CITY OF PORTLAND, MAINE  
DEVELOPMENT REVIEW APPLICATION  
PLANNING DEPARTMENT PROCESSING FORM  
DRC Copy

2005-0235  
Application I. D. Number  
10/12/2005  
Application Date  
Ruby Land #13  
Project Name/Description

61 - 61 Ruby Ln , Portland, Maine  
Address of Proposed Site  
342 B031001  
Assessor's Reference: Chart-Block-Lot

A3

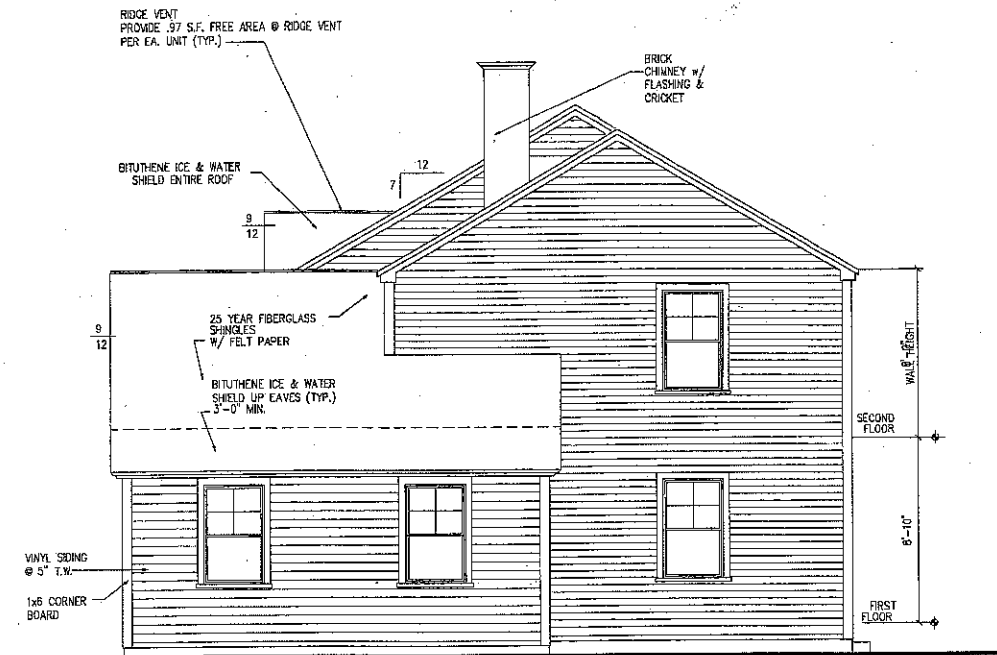
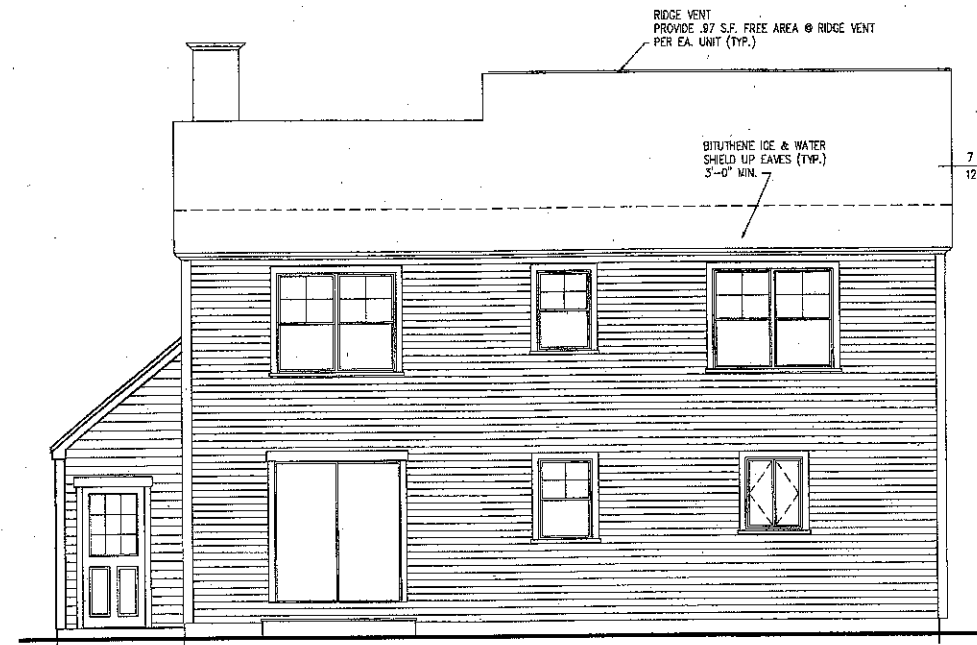
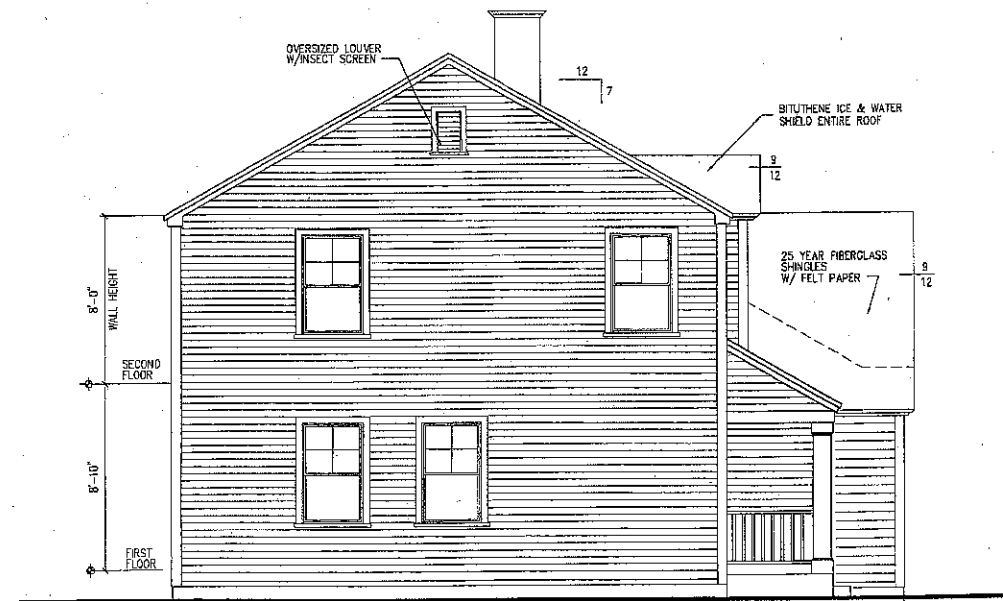
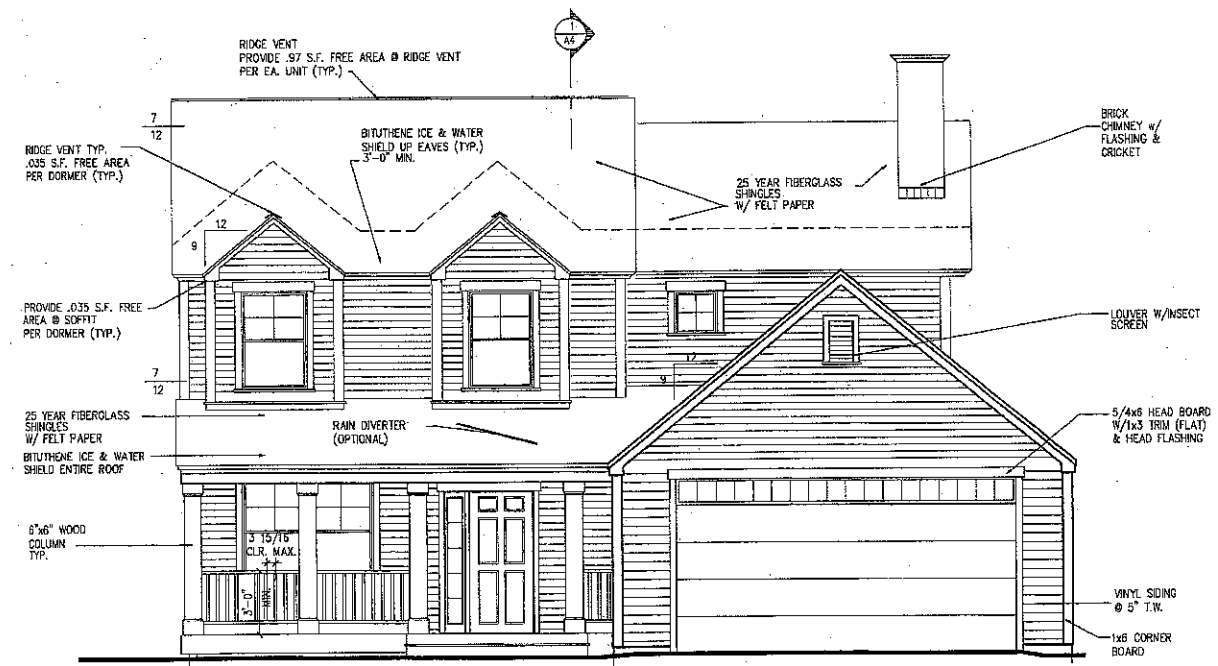
Max of Tree off Lot 1.5 - New Elevations  
Reverse Pitch in Rear  
Adjust FFE Accordingly  
Curb Cut location doesn't match S.B. Plans  
Label Zone in Rear
